Subject: Harmon (SPF-18-00008) Final Short Plat – Staff Review and Request for Additional Information

TO: Community Development Services
FROM: Taylor Gustafson, Environmental/Transportation Planner
DATE: January 3, 2019
SUBJECT: Public Works Review of Short Plat SP-18-00008 (Harmon)

K.C.S.P. NO. **SP-10-00007**
 Portion of NE1/4, SE1/4, SEC. 31, T20N, R17E &
 Portion of W1/2, W1/2, SEC. 32, T20N, R17E W.M.
 Kittitas County, Washington

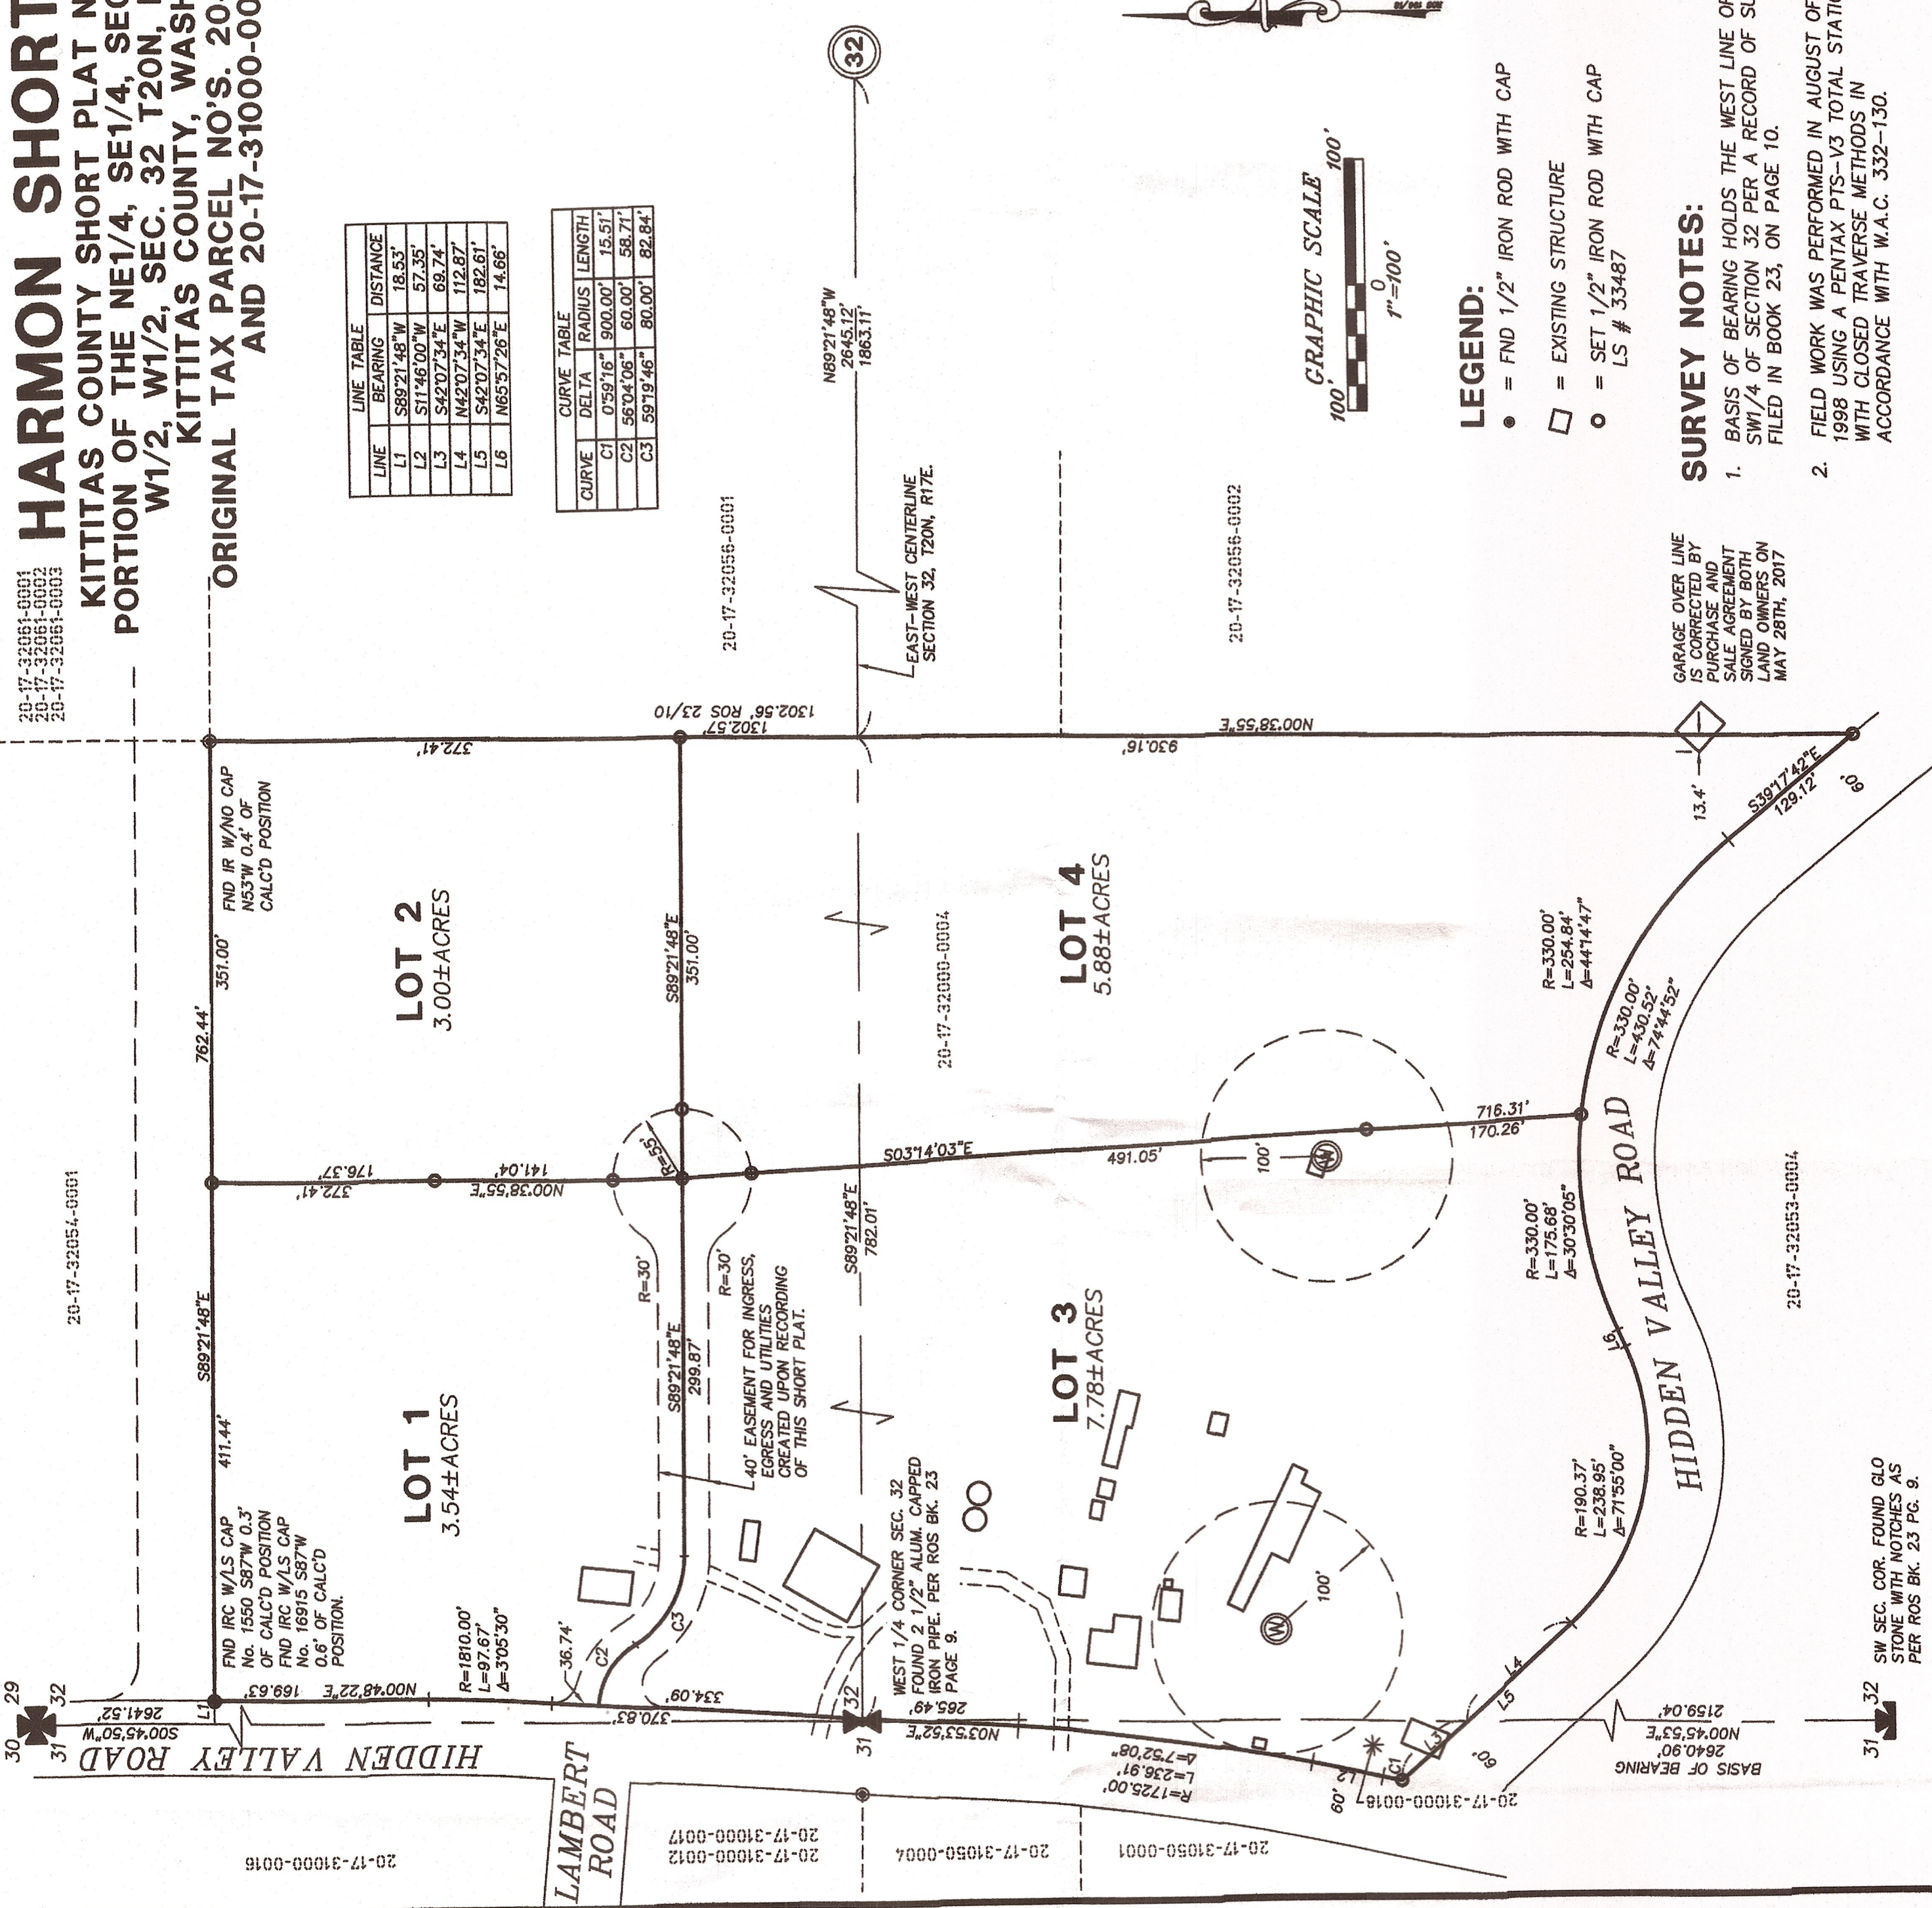
1. Some of the section corners shown do not have any details as to whether they were found, set, or calculated positions. Please note that one of the following requirements must be met for all GLO corners:

- a. Reference to recorded document identifying the position (ROS or LCR)
 - b. distance ties to 3 nearby reference points
 - c. distance ties to 2 adjacent GLO corners

2. All roadways must show name, width, underlying ownership, (Private/County/State), easement or R/W and surfacing material.
(EX: Hidden Valley Rd – 60' County R/W – Paved)

3. The relationship between the property lines and the section lines are confusing, particularly in the area near the West $\frac{1}{4}$ corner of Section 32. The use of "crow'sfeet" to reference what line segment the distances refer to would be useful. It is uncertain what the distance shown as "265.49" is referring to, and whether the section corner actually falls on the property line.

4. The due to the geometry of the curve labeled as "C1" it is difficult to deduce whether it is a curve to the left or the right. A note, a chord bearing, or showing a portion of the radial lines (or any other suitable method) would clarify.

5. The radius of the curves on the proposed 40' easement at Hidden Valley Road are missing.
6. The buildings should be labeled. (Shop/Barn/House/etcetera)

7. The 100' circle around the Wells should be labeled as "100' Well Protection Zone".
8. If the intent of the wells is to serve multiple parcels, please include access and utility easements to provide owners with access and supply water to the respective parcels.

9. Identify the amount of trespass onto the Hidden Valley Road R/W, near the SW corner of Lot 3.
10. Change the language of the garage trespass near the SE corner of Lot 4 to "Garage over line is *accepted*...."

11. Acreage shown to 2 decimal places is considered an acceptable level of accuracy. The +/- symbol shown with the acreage is typically utilized for irregular natural boundaries or very large tracts of land. Please include a note if there is a reason the acreage cannot be accurately determined.

1. Applicant is herein notified that the structures nearest the proposed 40' easement would be re-classified as existing non-conforming due to the front setback, which may limit development of said structures.
